KIRKLEES METROPOLITAN COUNCIL INVESTMENT & REGENERATION SERVICE

DELEGATED DECISION TO DETERMINE PLANNING APPLICATION FOR ADVERTISEMENT CONSENT

Reference No:	2025/64/92472/W
Site Address:	Part of former St Luke's Hospital site, Blackmoorfoot Road, Crosland Moor, Huddersfield, HD4 5RA
Description:	Erection of illuminated signs
Recommending Officer:	Joshua Merriman

DECISION – Advertisement Consent - Granted

LIDL SMALL WALL MOUNTED BILLBOARD
1:20

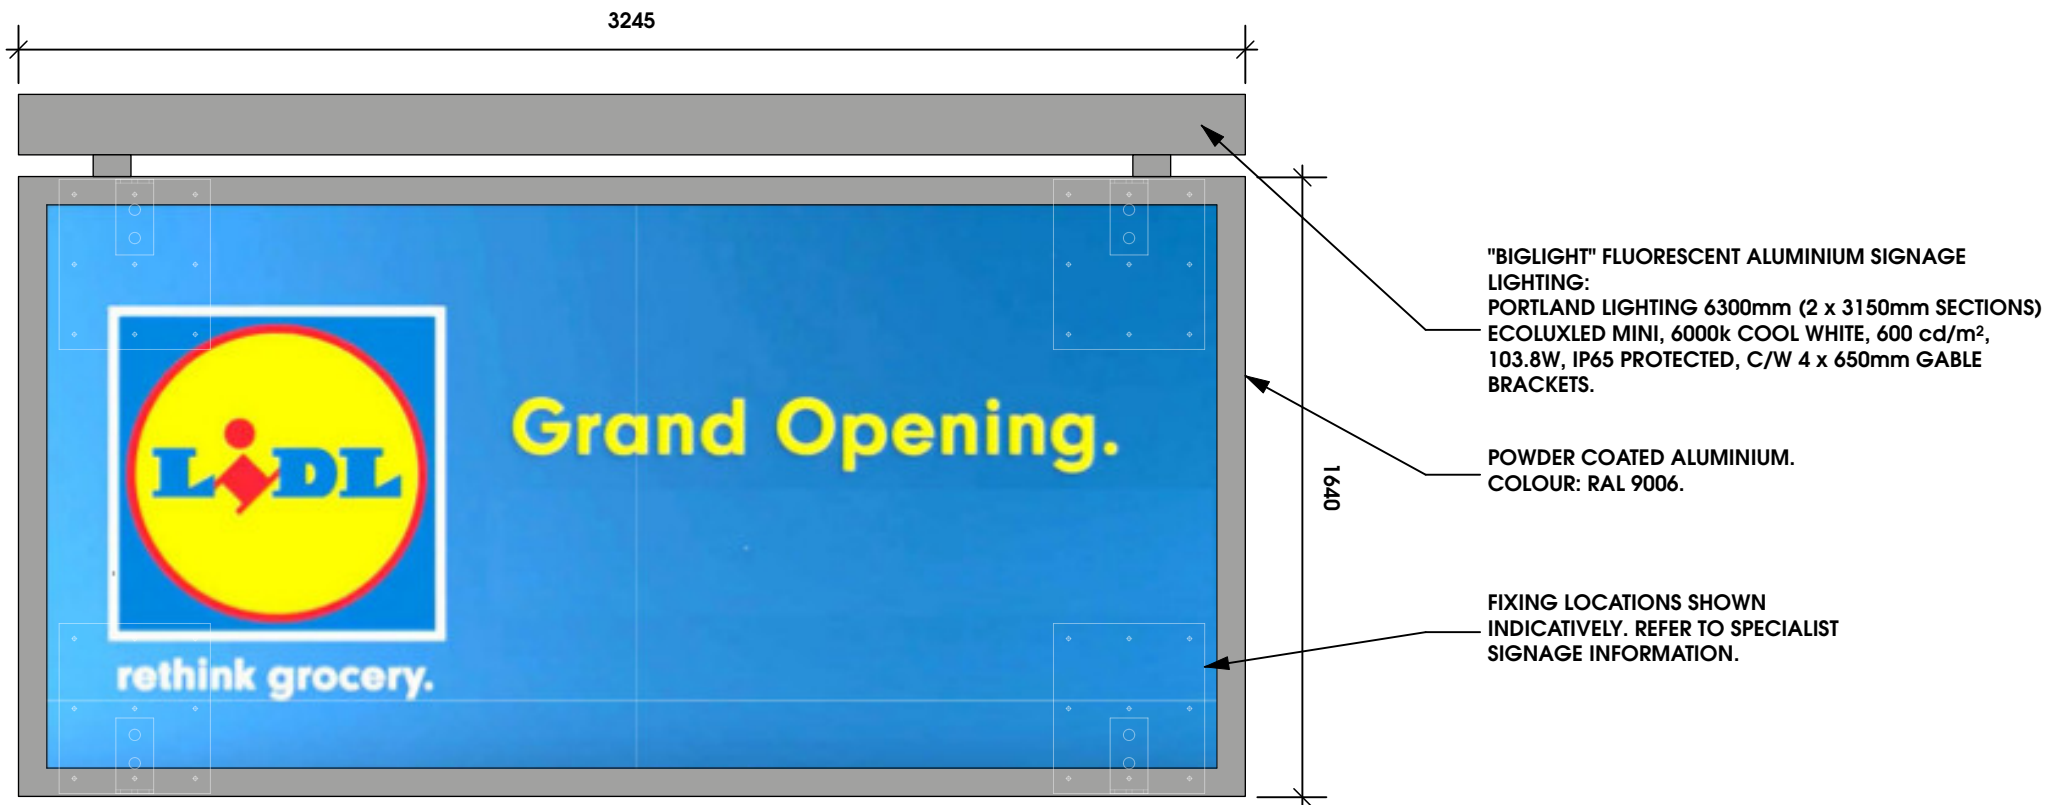
The dimensions of the proposed small wall mounted billboard are detailed below:

- Height: 1.64m.
- Width: 3.245m.
- Depth: 0.2m.

The sign will be externally illuminated at an illuminance level of 600 cd/m², therefore, as this exceeds the allowed illumination levels during hours of darkness within an urban area, a condition is recommended to be attached should the consent be approved that the sign must be turned off overnight.

The proposed small wall mounted billboard is considered to be of an acceptable size and design that is consistent with the surrounding street scene and character of the local area.

6. The hereby approved flagpole sign, large wall mounted billboard, and small wall mounted billboards shall be switched off between the hours of 22:30 and 07:30 on any day.

project  
Blackmoorfoot Road  
Huddersfield  
drawing title  
Proposed Lidl Directional  
Signage

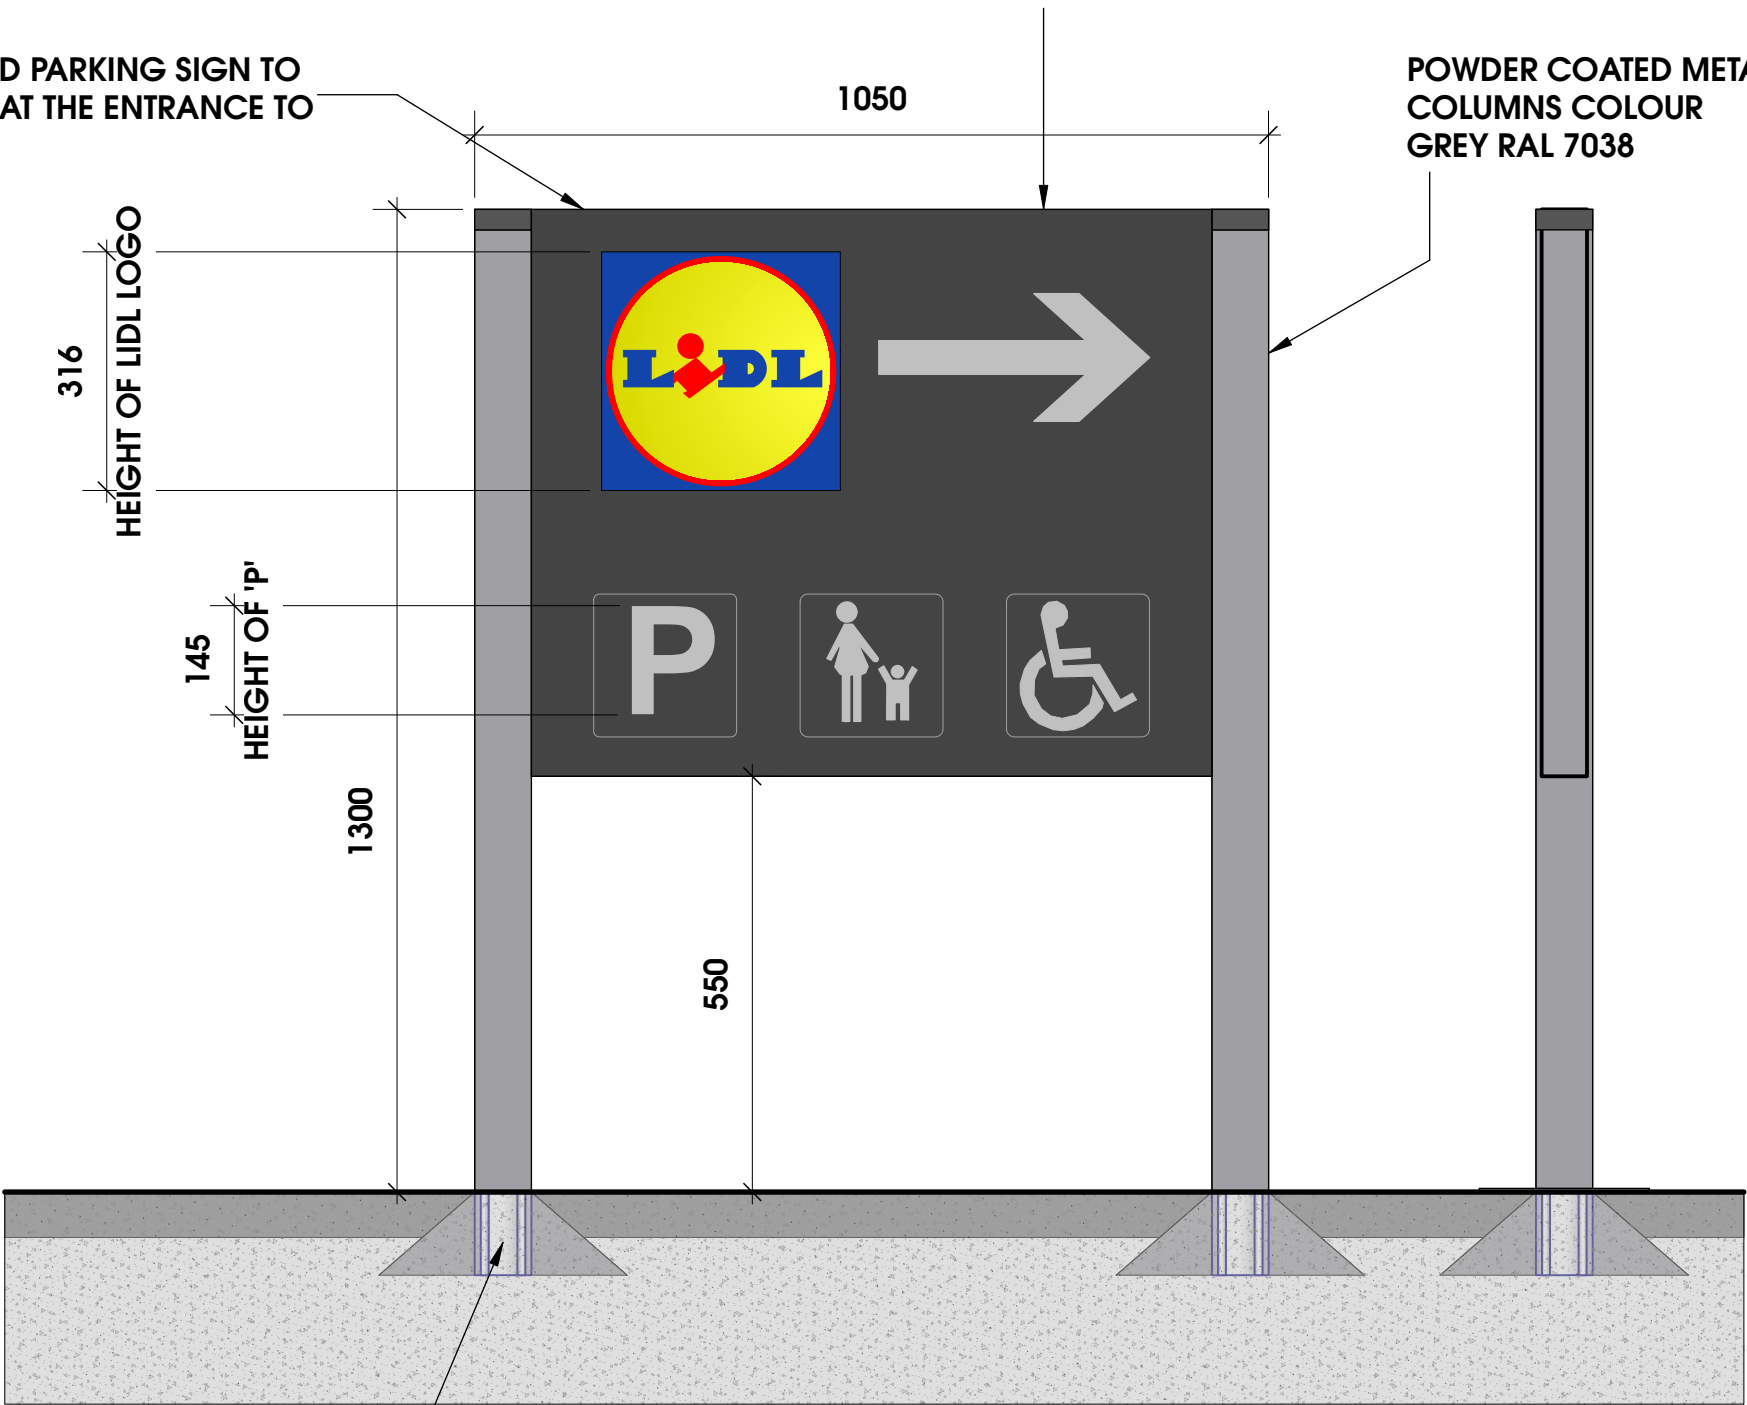
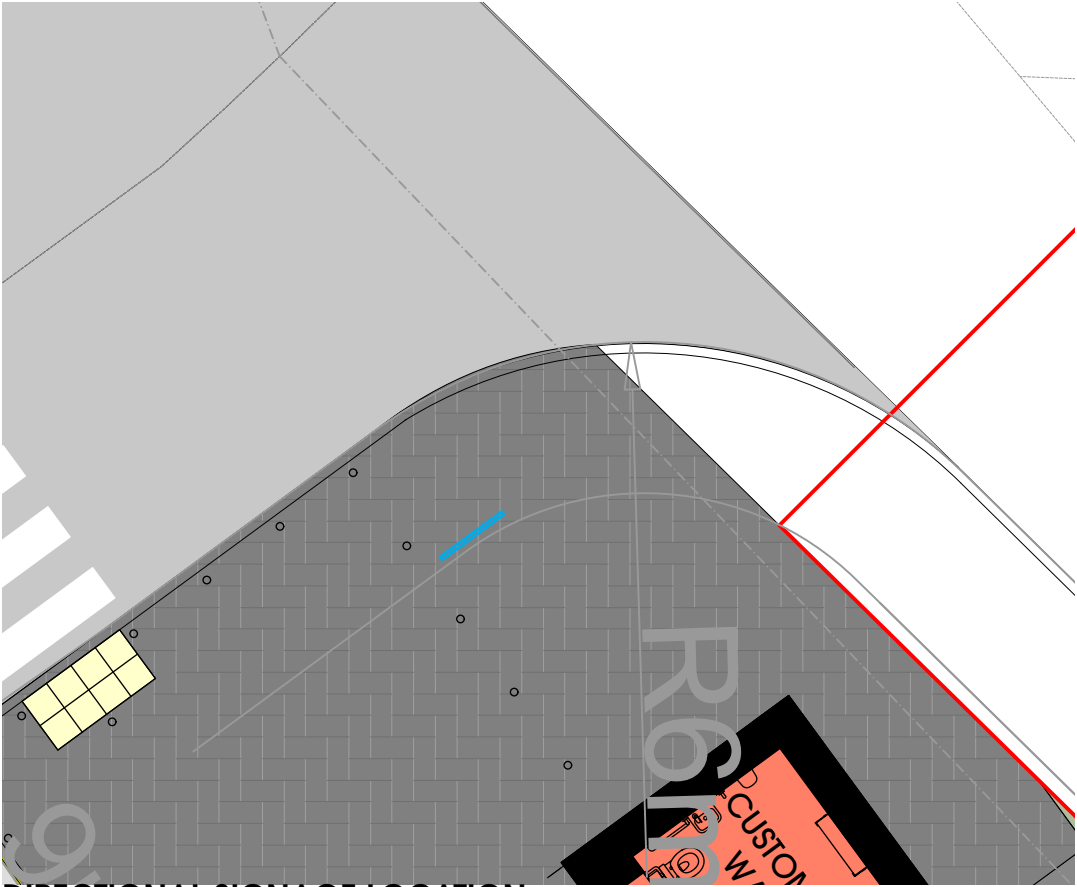
The details of the proposed directional signage are found below:

- Height: 0.75m.
- Width: 1.05m.
- Depth: 0.1m.

The sign will not be illuminated and will be coloured in blue, red, yellow, and grey. The proposed directional signage is considered to be of an acceptable size and design that is consistent with the surrounding street scene and character of the local area, with no objections from KC Highways Development Management.

POSTER DISPLAY UNIT LOCATION
1:50

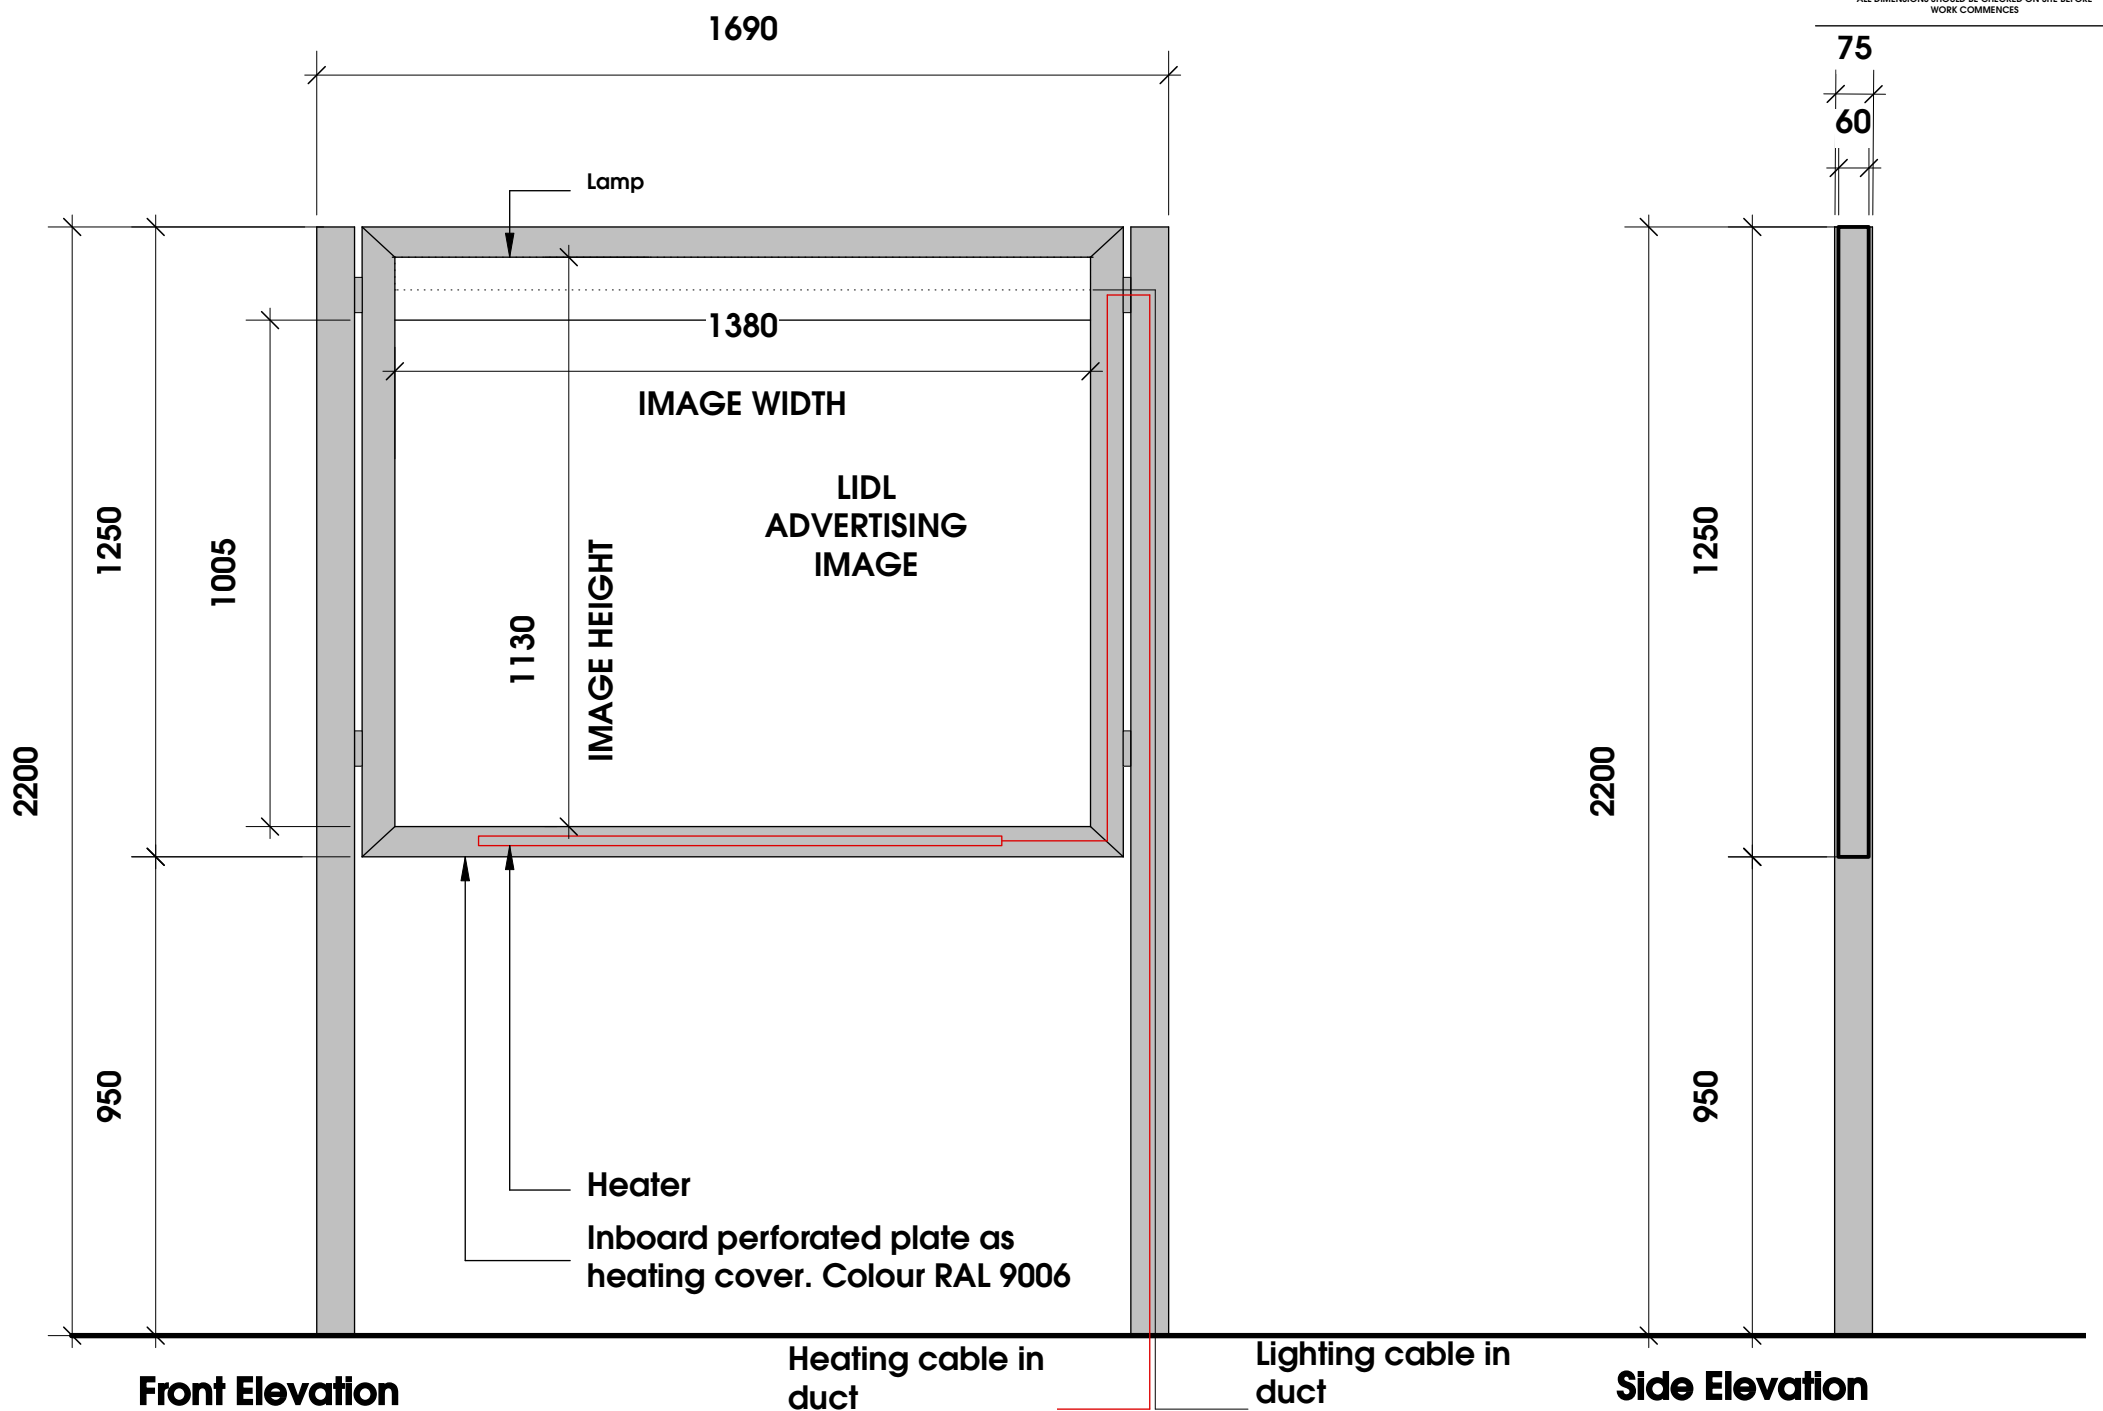
Details of the poster display unit are detailed below:

- Height: 1.25m.
- Width: 1.69m.
- Depth: 0.075m.

The sign will be illuminated internally at an illuminance level of 225cd/m² which is also within the permitted luminance for the location in all hours. The proposed poster display unit is considered to be of an acceptable size and design that is consistent with the surrounding street scene and character of the local area.

drawing title  
**Proposed Lidl Flagpole  
Details**

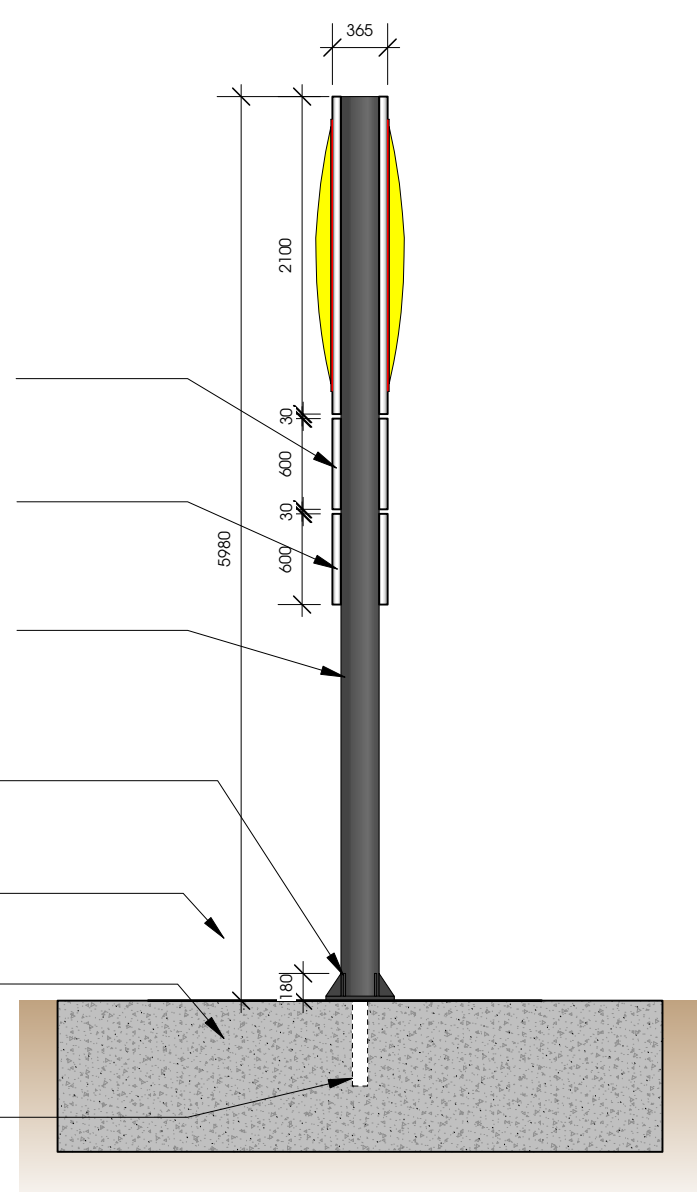
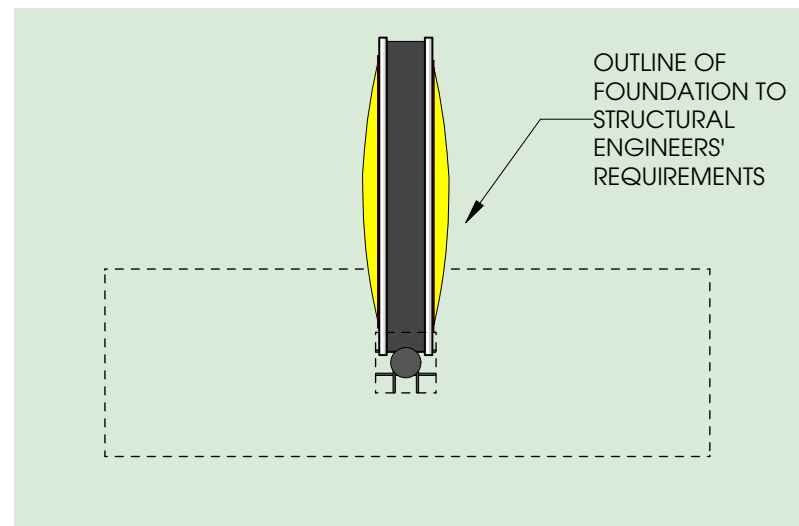
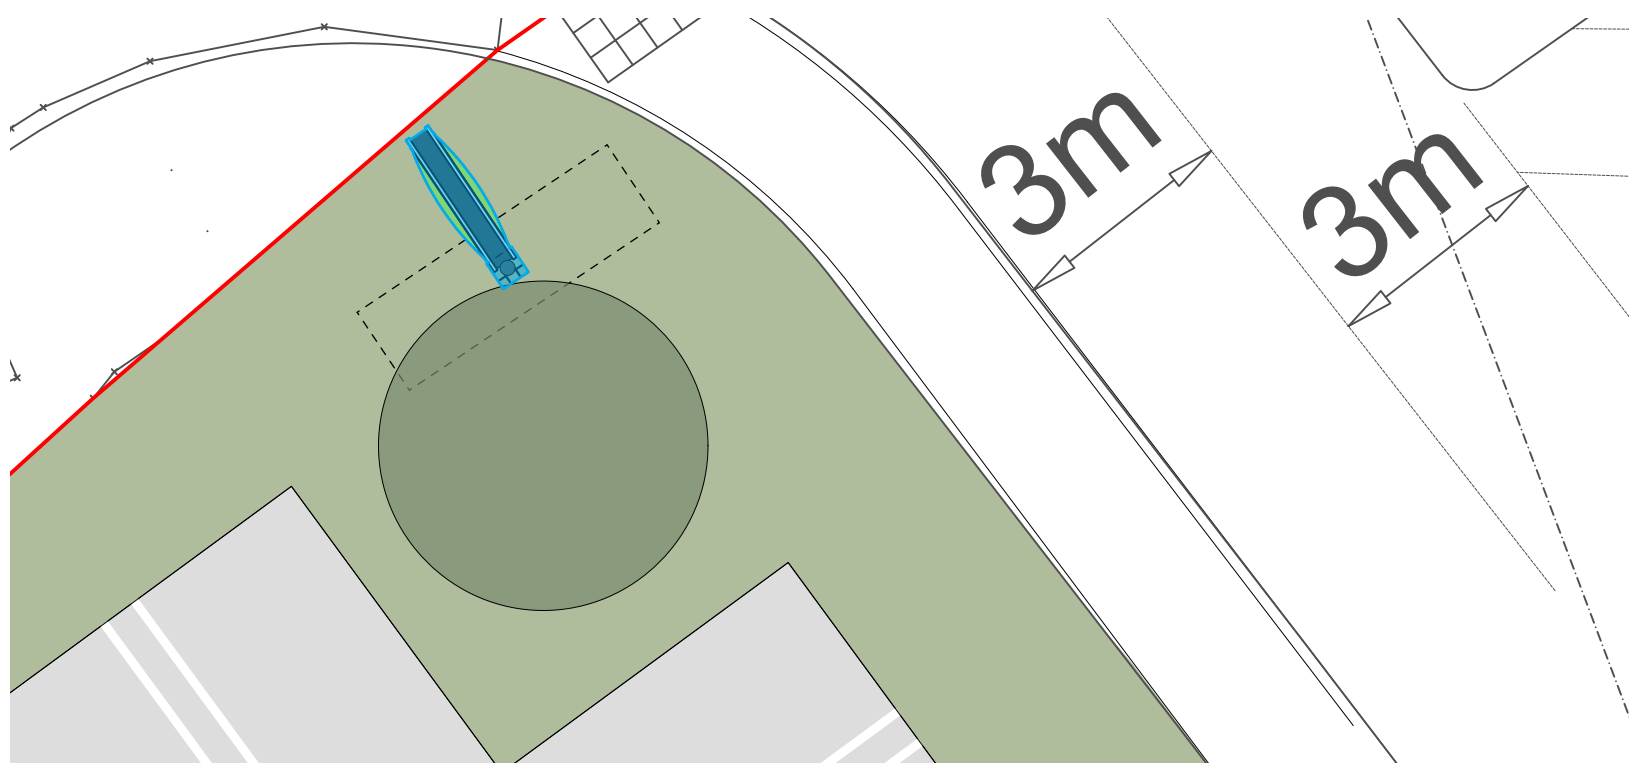
Finally, information regarding the proposed flagpole sign is detailed below:

- Height: 3.36m.
- Width: 2.1m.
- Depth: 0.365m.

The flagpole sign will be internally illuminated at an illuminance level of 460cd/m² which is above the maximum permitted luminance level for an urban area, therefore a condition is recommended to be attached should the consent be approved that the turn off overnight also relate to this flagpole sign. The proposed flagpole sign is considered to be of an acceptable size and design that is consistent with the surrounding street scene and character of the local area.
